Consultation Response from KC, Highways Development Management
2026/92181 rear of, 19, Helme Lane, Meltham, Holmfirth, HD9 5PF
Erection of detached dwelling
Date Responded: 9 September 2026 Responding Officer: Sheila Henley Responding Ref: 3-7/25

Plan ref: 26-024-02 Planning
Reference to planning approval: 2023/92751

ground floor plan

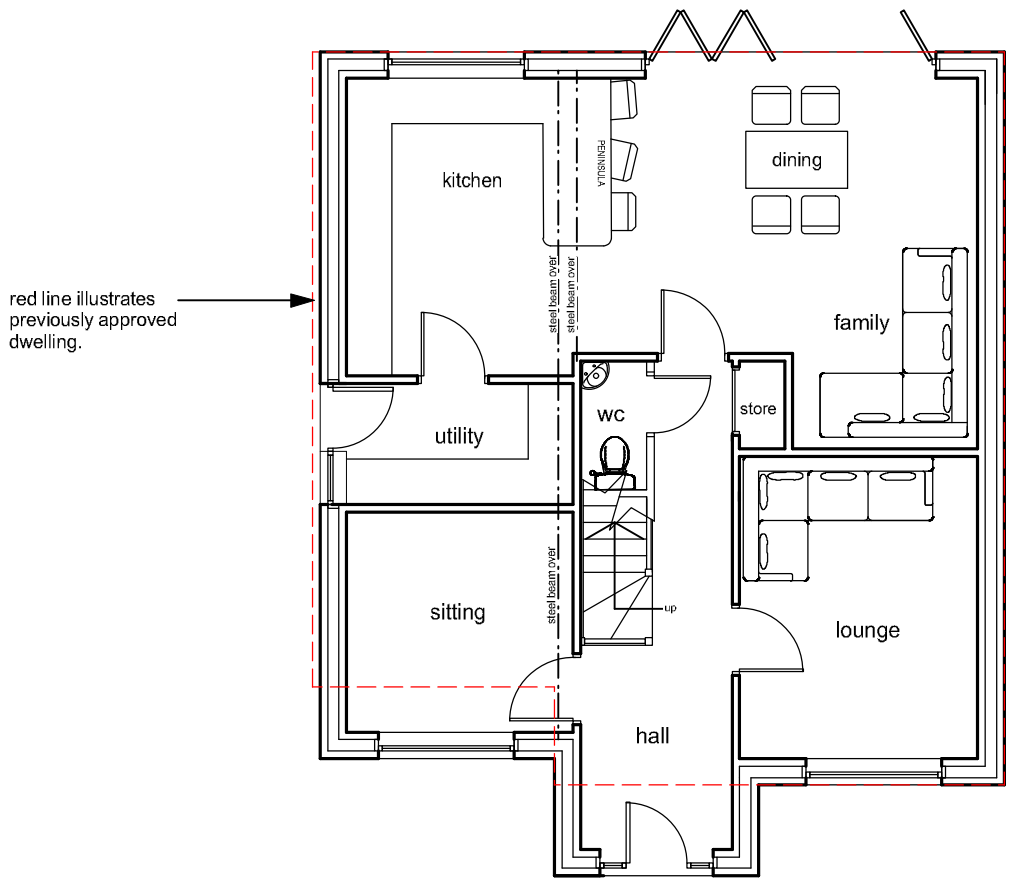
Cycle parking could be provided within the garage to support policies LP20 and LP22, Active Travel objectives and mode choice. The garage could accommodate one space per dwelling as desired under the Kirklees Highway Design Guide SPD or one per bedroom under the later guidance in LTN1/20.

site plan 1/200

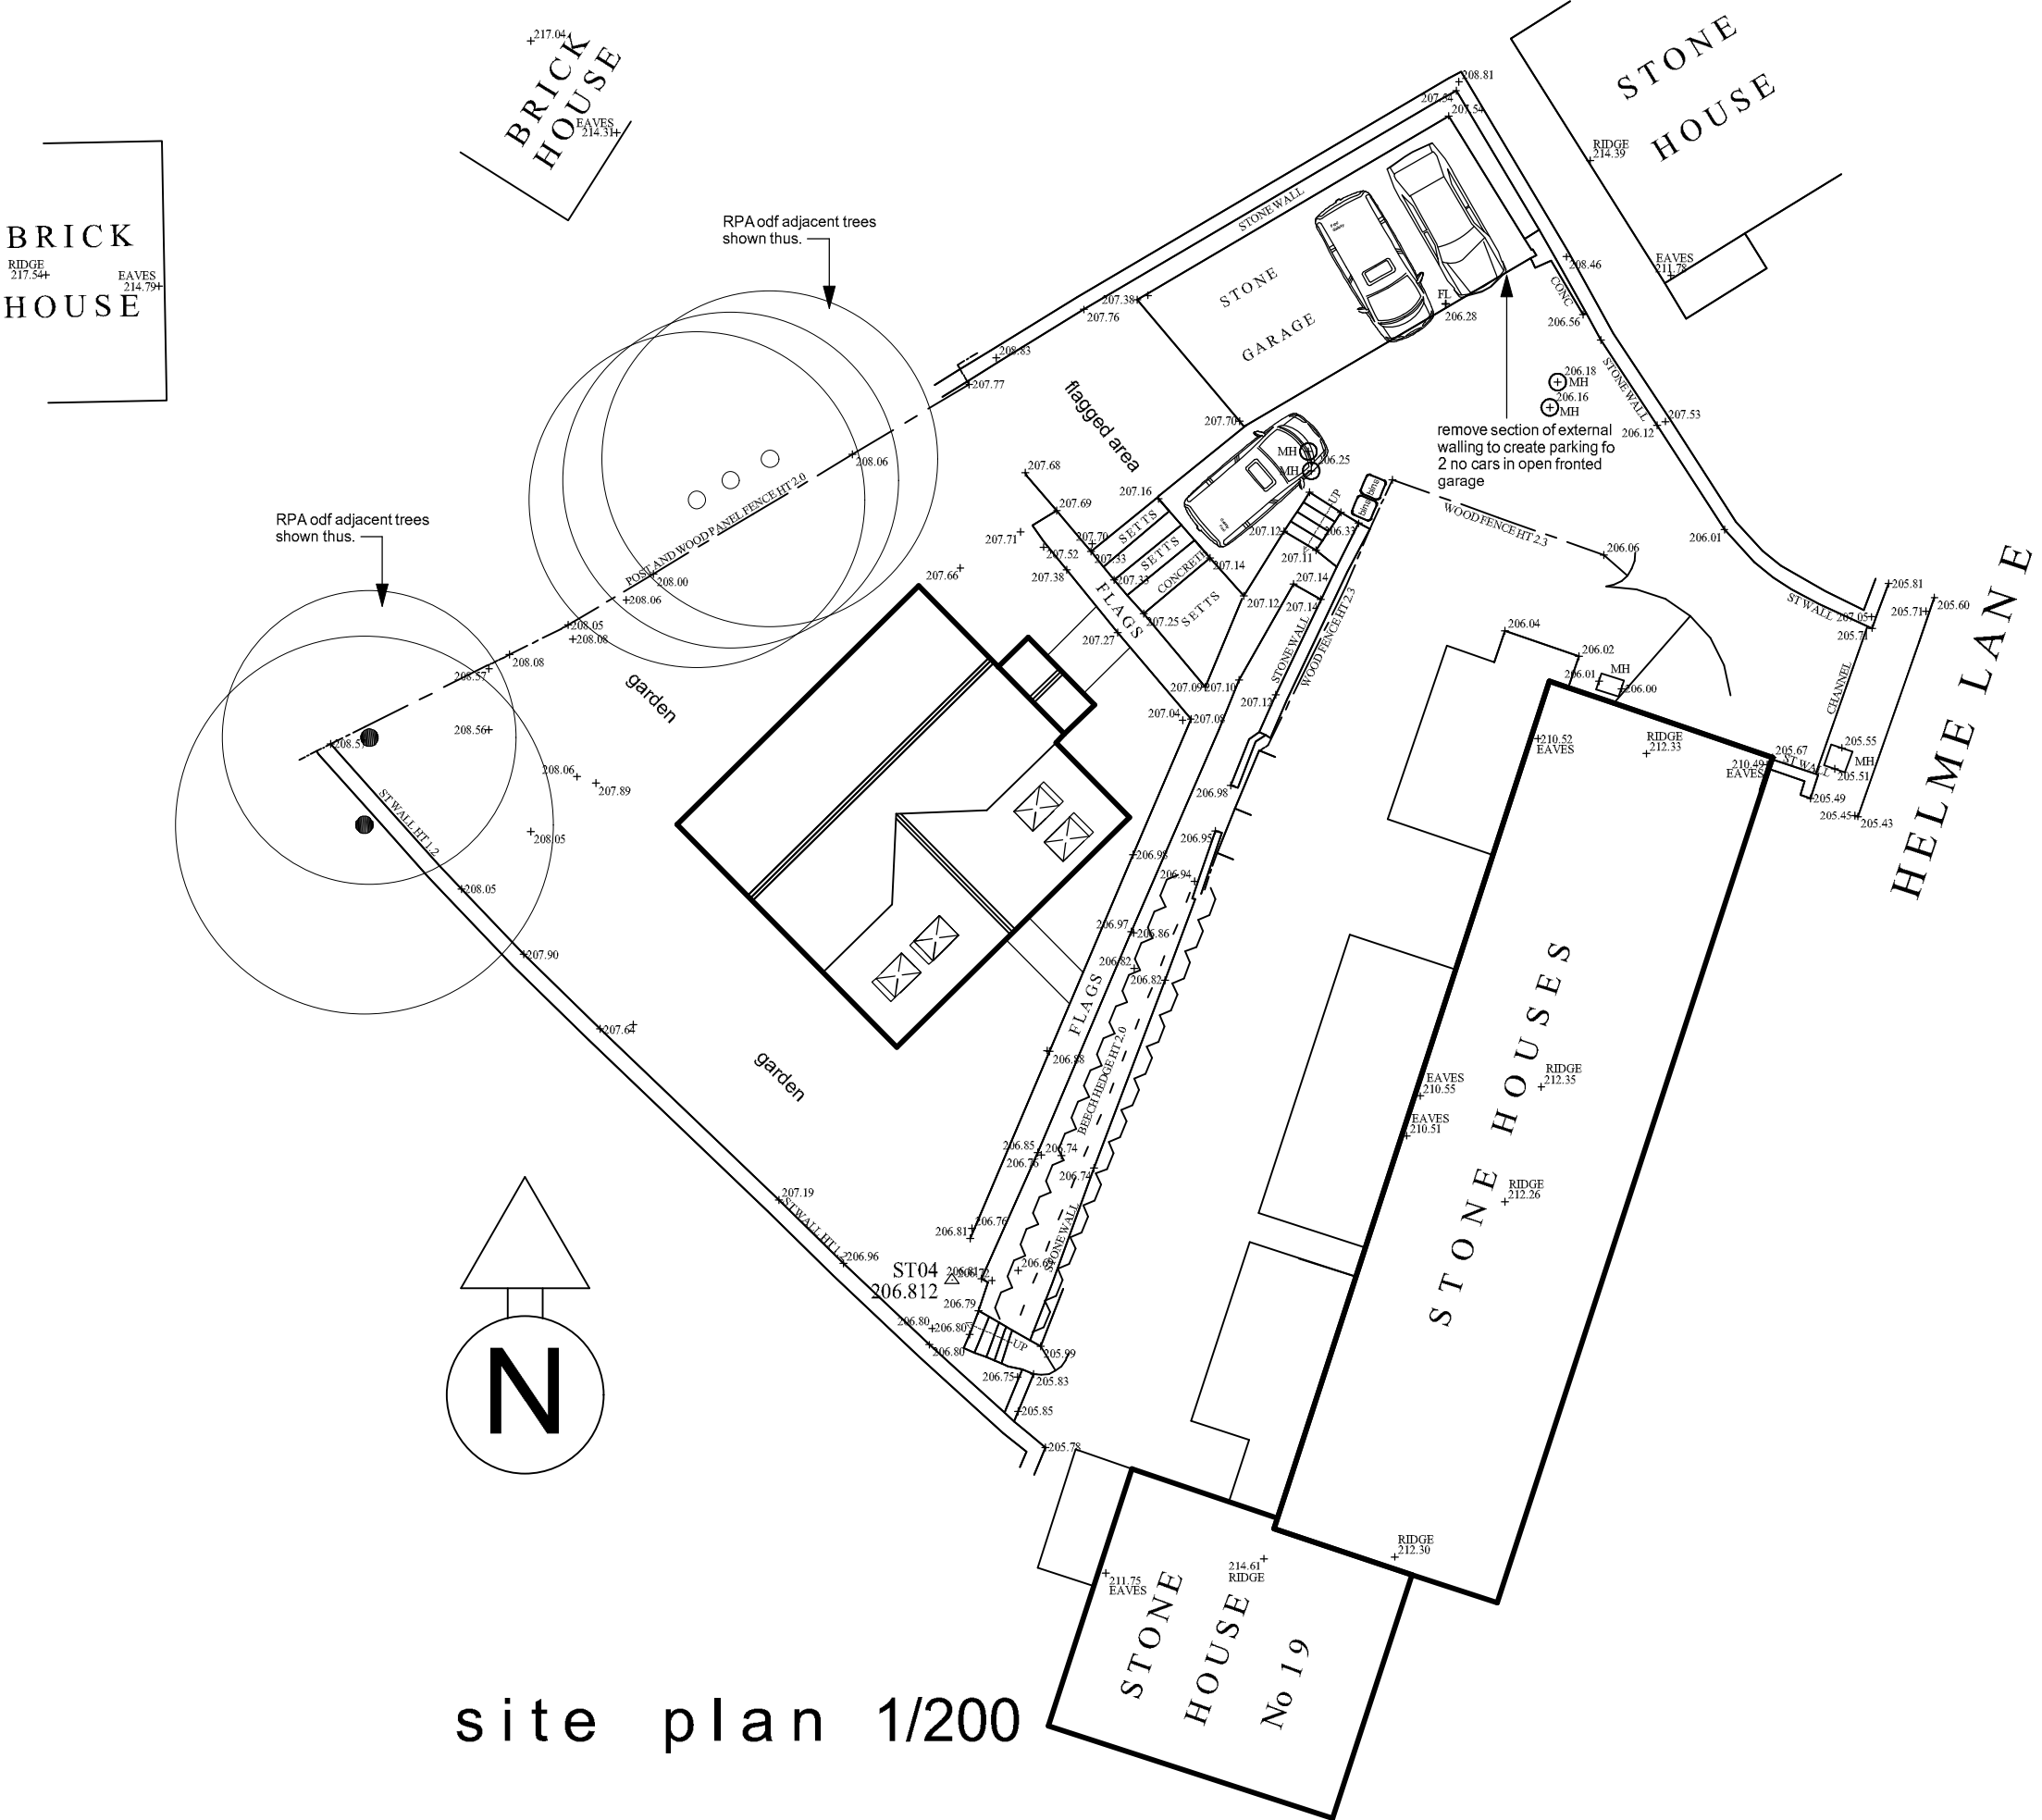
The existing access from Helme Lane is to be retained to the north of no.27. Its layout is adequate and previously accepted, such as for the last planning approval 2023/92751/

Within the site there are areas of hardstanding for parking and turning as well as garaging which are of adequate dimensions to accommodate at least three car parking spaces as recommended in the KHDG SPD for four bedroomed houses. There would be flexibility to meet policy LP22 with space for visitors too.

There is space for bin storage; although pull distances could be quite long depending on its position and the Applicant is advised to consider its location to comply with building regulations.

A fire and rescue appliance would be able to reach the intended dwelling from Helme Lane.
